**MANSTON AIRPORT DEVELOPMENT CONSENT ORDER EXAMINATION**

**SUBMISSION TO DEADLINE 9:**

**Comments on Information requested by the ExA**

**Comment on PD-018 - Requirement 9b, Noise Mitigation**

Figure 12.6
Aircraft noise - daytime $L_{Aeq,16hr}$
contours - year of forecast maximum
capacity

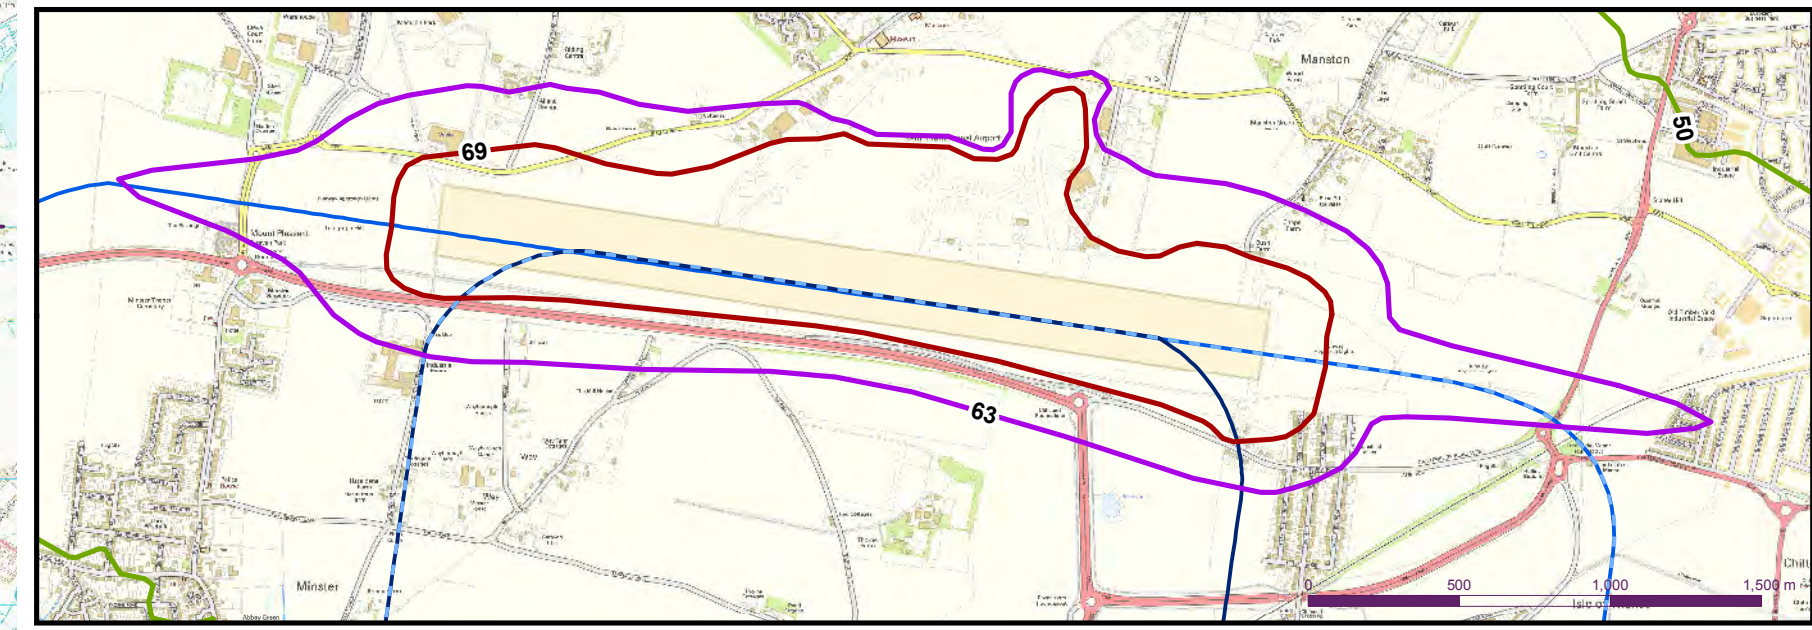
7.4. Given that the LAeq 16hr noise contours produced by the Applicant in its Environmental Statement show only three noise contours at 50dB, 63dB and 69dB<sup>4</sup>, it is impossible for any Interested or Affected Parties in the local area to identify whether they fall in any other noise contour - including, for example, 57dB or the 60dB contour. Indeed, the Applicant’s noise contours give the somewhat misleading impression that everyone outside the 63dB contour falls under a 50dB noise contour.

7.5. As such, it is highly unlikely that any Interested or Affected Parties in the local area can claim to have been properly consulted at all on this issue - whether separately or otherwise - as is a requirement under paragraph 3.40 of the APF.

15. Due to the unique character of residential properties in and around Ramsgate, a **tailored** compensation scheme should be put in place, in keeping with paragraph 3.40 of the Airport Policy Framework, and with the threshold at which properties may be eligible for compensation and mitigation **starting no higher than 57dB LAeq (16 hour)**, based on the CAA ERCD noise contours and **with 100% of costs covered**.

(iv) The **Noise Mitigation Plan** [\[REP8-004\]](#) is amended at paragraph 7.1.2 to include Forecast LAeq noise contour reporting requirements at **57dB LAeq** (16 hour) in addition to contours already included in this paragraph.
